**Great North Road Solar and Biodiversity Park – Issue Specific Hearing 3 (ISH3)**

**Wednesday 4<sup>th</sup> February 2026**

Summary of Verbal Representations from Newark and Sherwood District Council (NSDC)

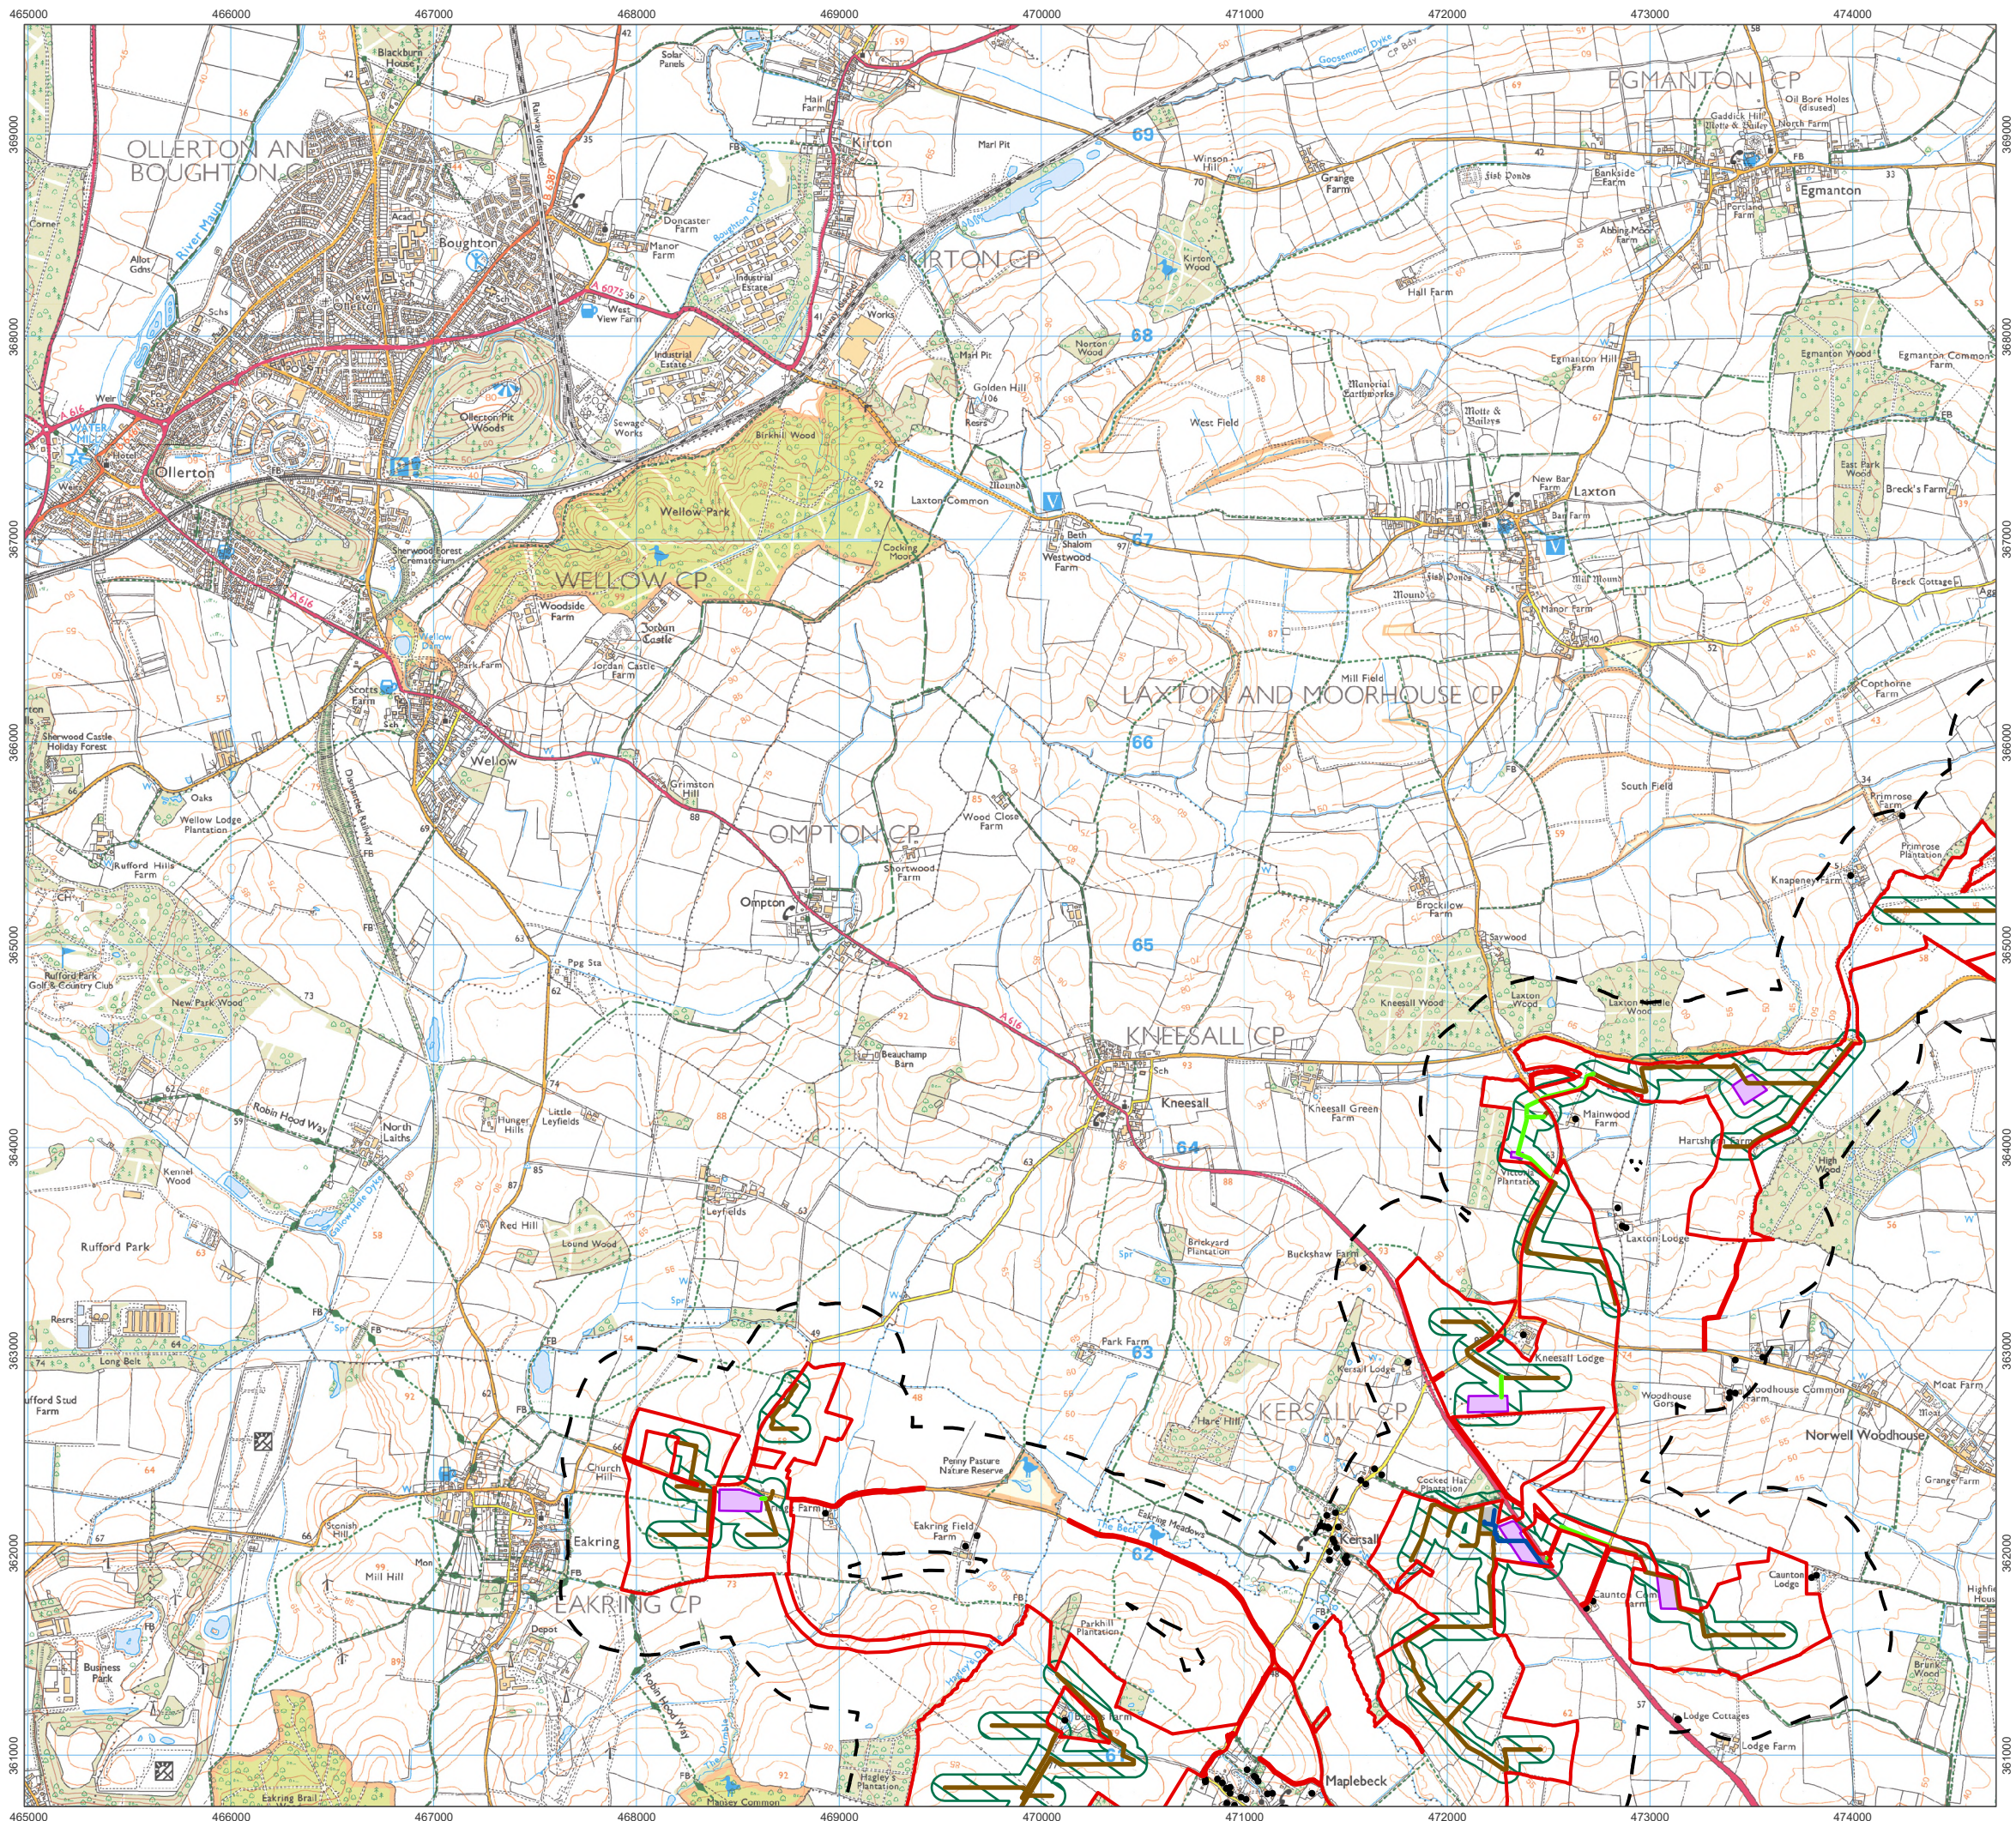
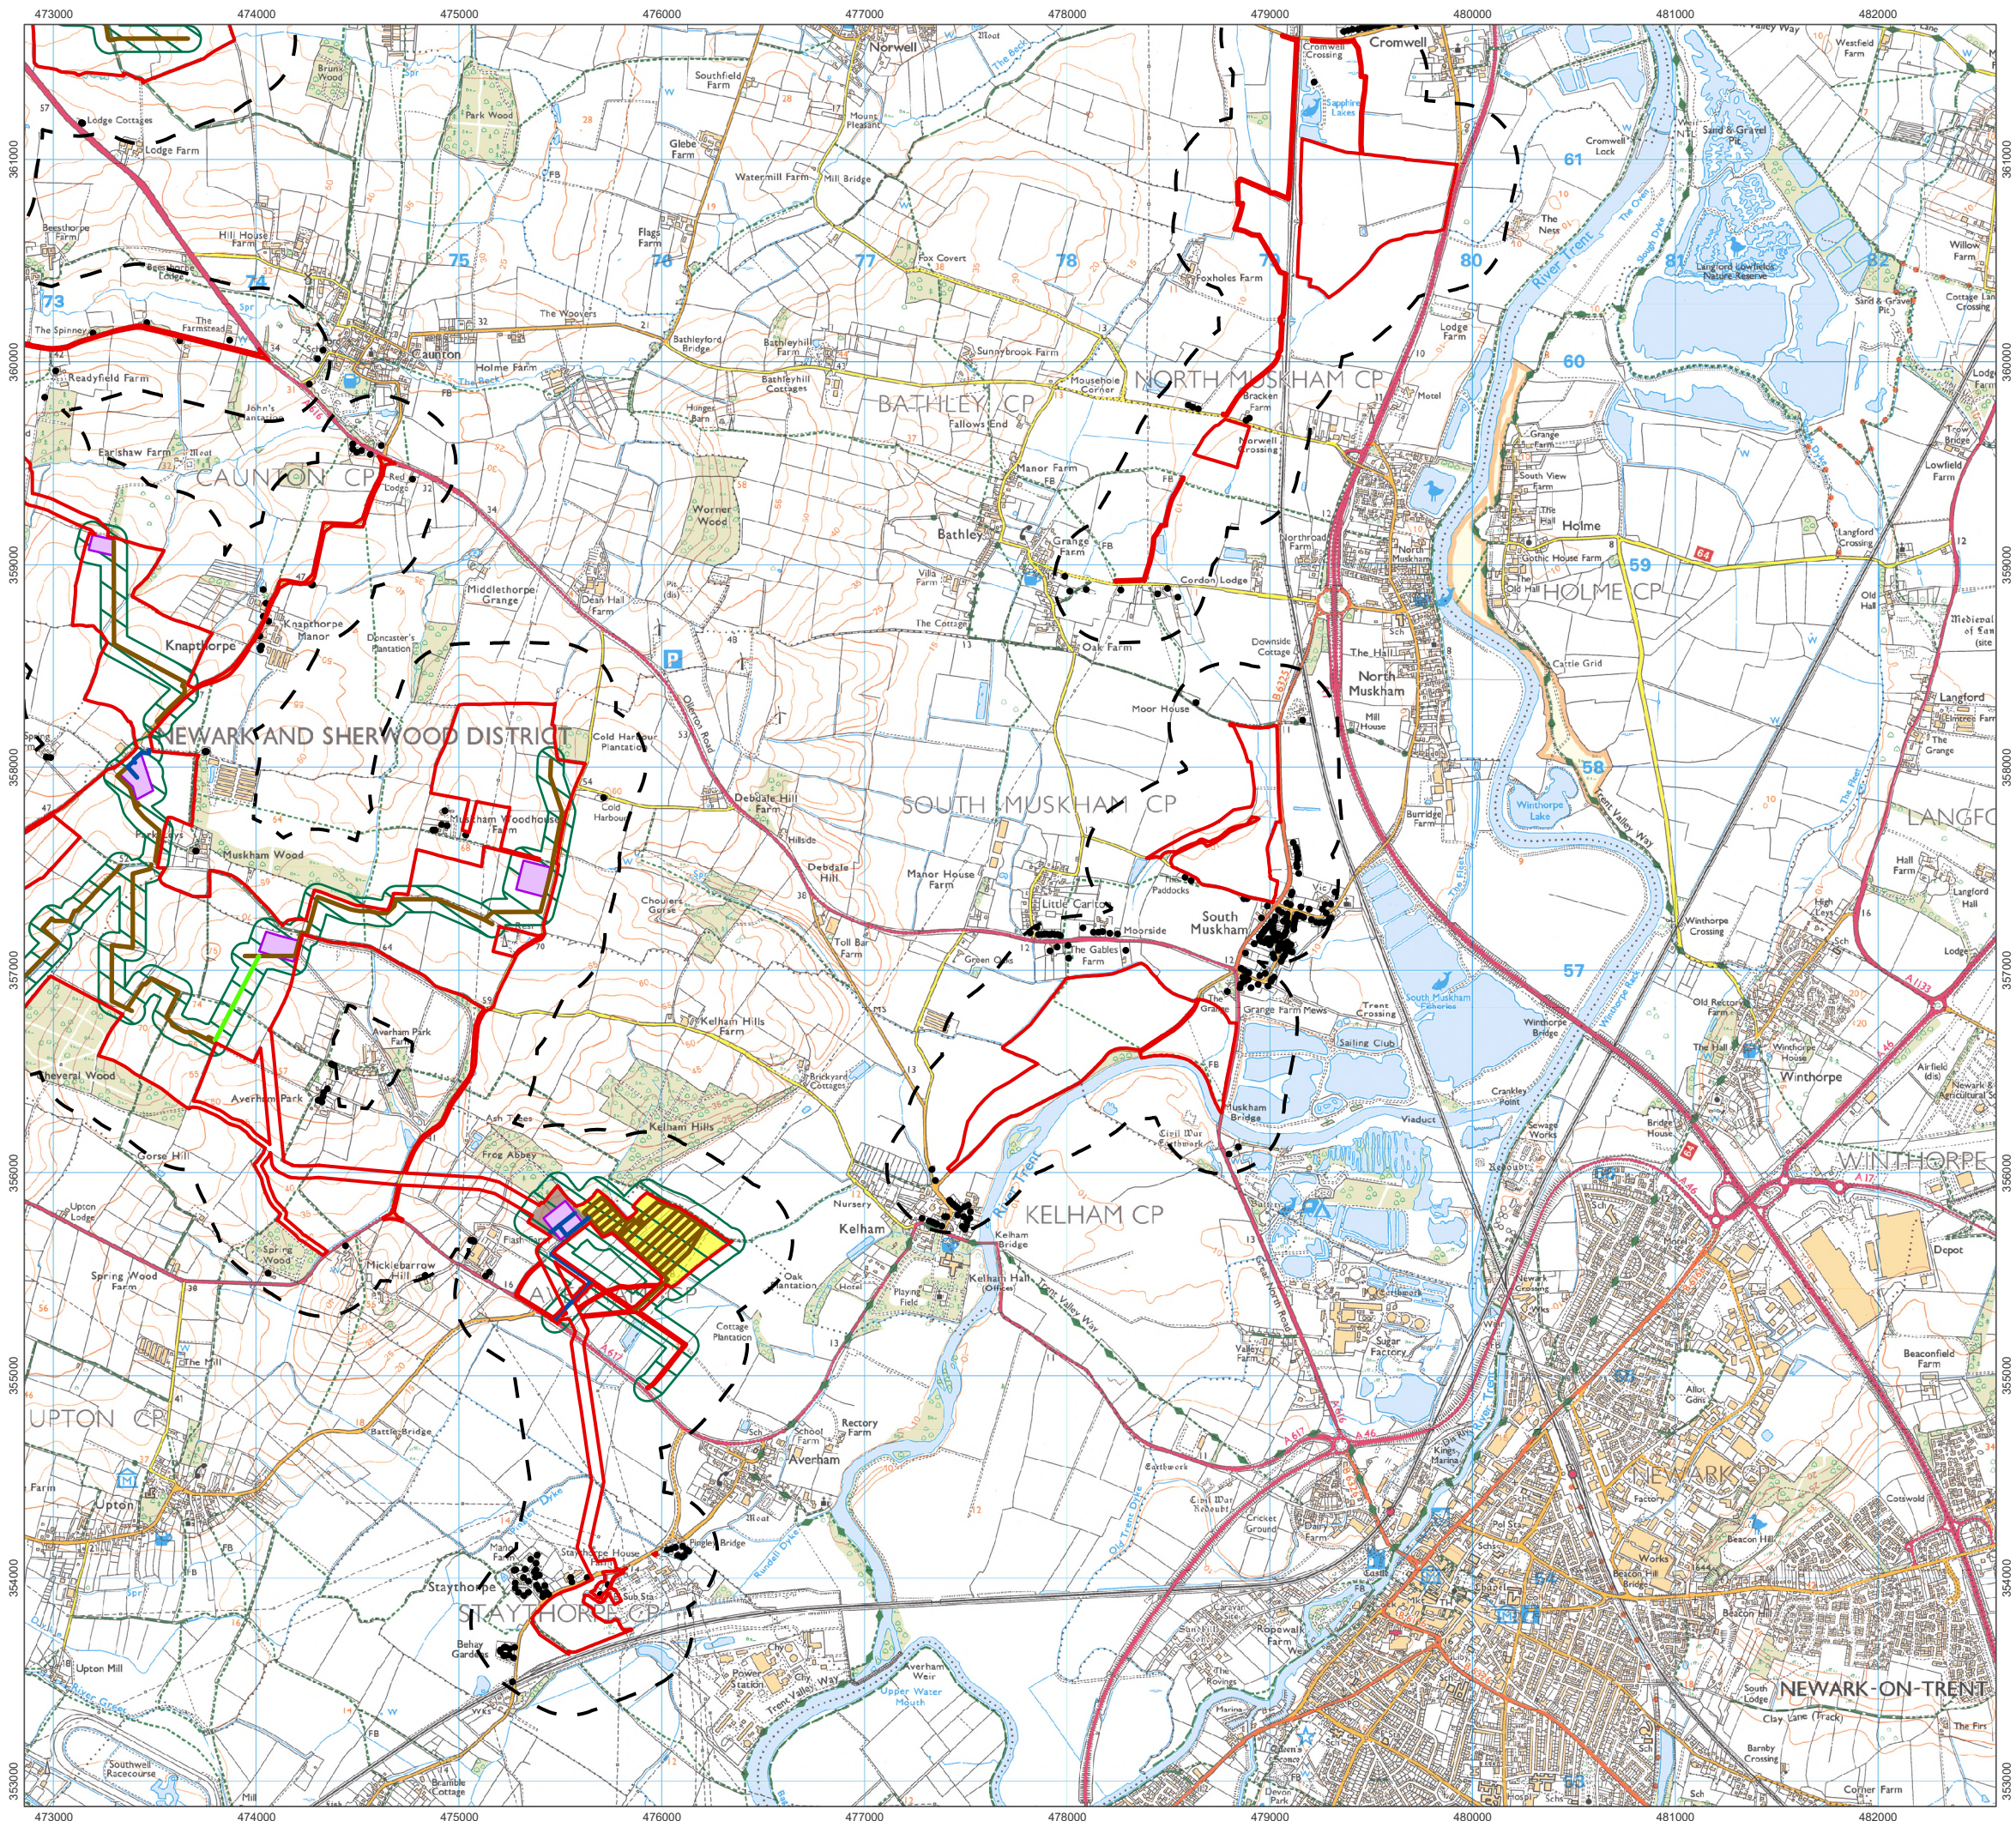
19. NSDC confirmed their opinion that the applicant has used appropriate thresholds for noise, derived from appropriate standards. Receptors have been identified within areas where noise levels are above the threshold, however the modelling assumes a 'worse case' with all noise sources operating continually and simultaneously, with no screening or other attenuation. Details of measures to control noise are to be provided through submission of a Construction Environment Management Plan (CEMP) and Noise Management Plan (NMP).
